CITY OF ALBUQUERQUE

December 5, 2011

**Re: Car Crafters – Automotive Repair Garage, 5404 Edith Blvd NE,
Traffic Circulation Layout
Architect's Stamp dated 10-20-11 (F15-D036)**

BUILDING AREA: 20,944 SF

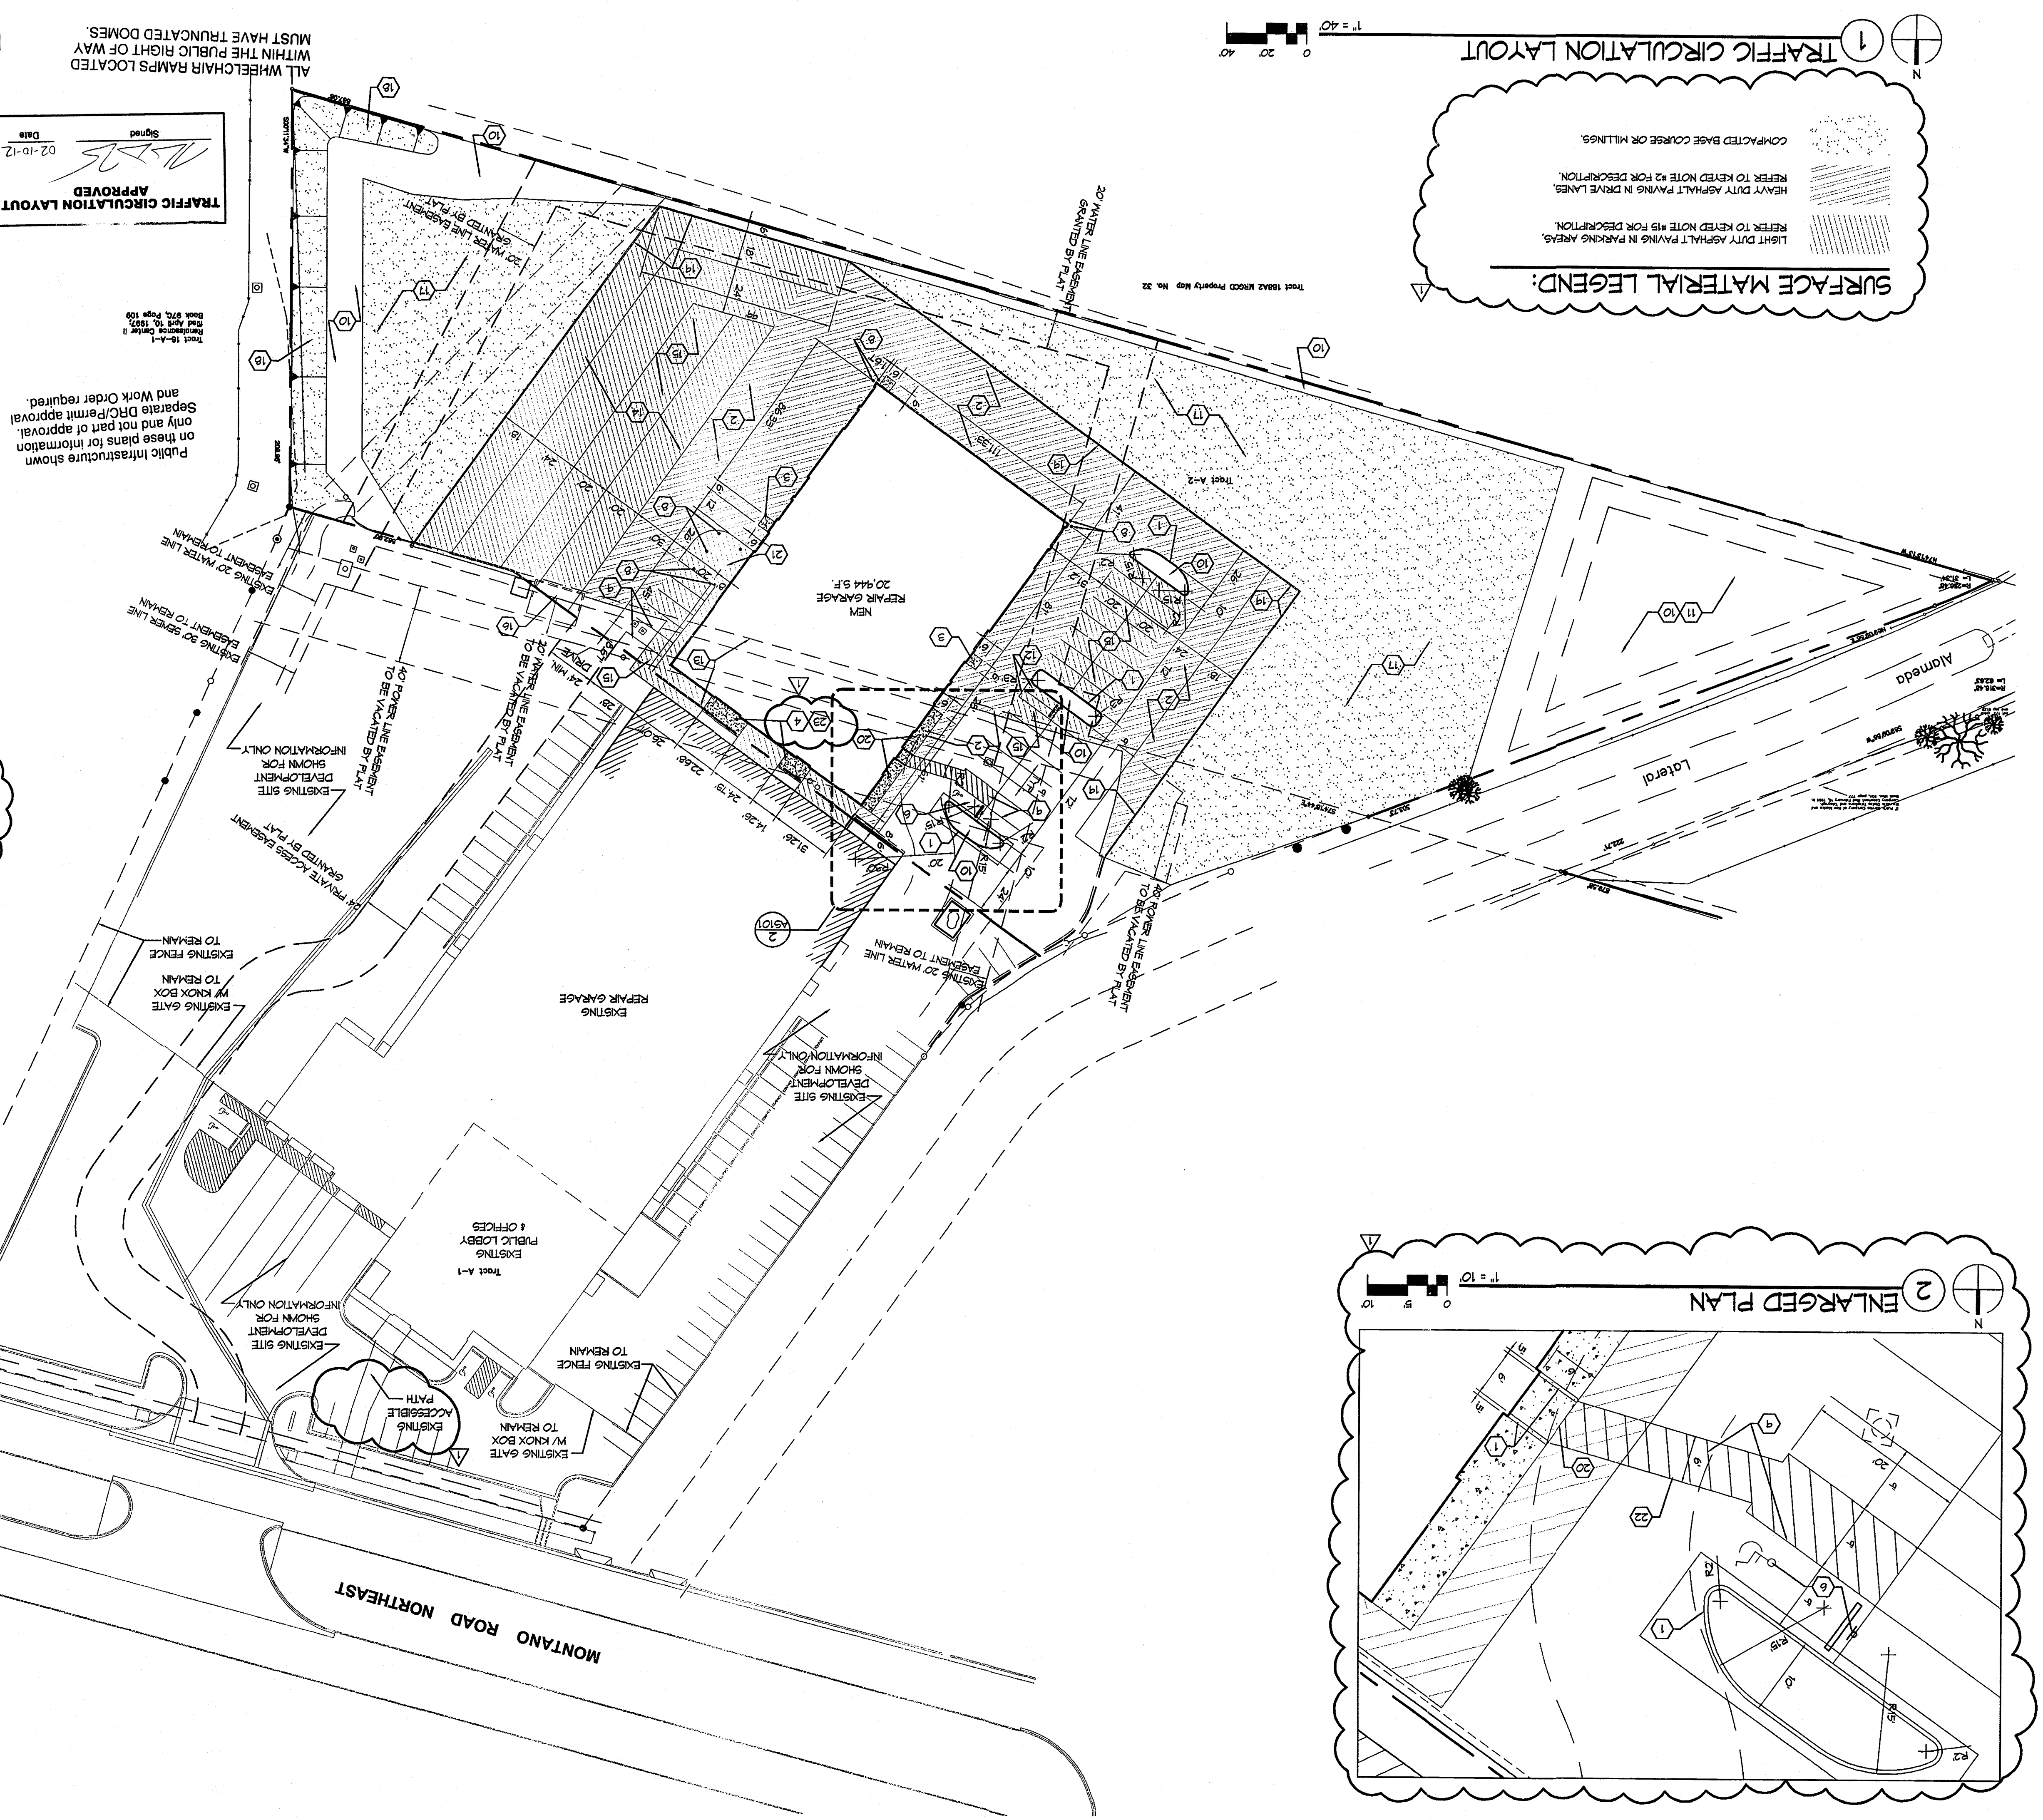
1. Please clarify the status of the proposed platting action. What is the DRB project number? An approved preliminary plat must be provided prior to building permit approval.

2. Clarify how the proposed access easement will function with the existing Knox box shown on site. This information must be provided on the plan.
3. The site layout indicates access will be shared at the northeast and northwest corners of the site. However, an access easement is shown only in the northeast corner of the site. Please revise.

4. Provide a legend identifying all hatching and linetypes.
5. Parking spaces cannot cross the lot lines.
6. The proposed concrete walkway cannot be flush with the asphalt, as this places it directly within the vehicular way.

7. Clearly indicate the 6-foot wide, ADA accessible pathway from the handicapped parking stalls to the building.
8. Clearly indicate the 6-foot wide, ADA accessible pathway from the roadway to the building.

9. Define the width of all parking stalls.
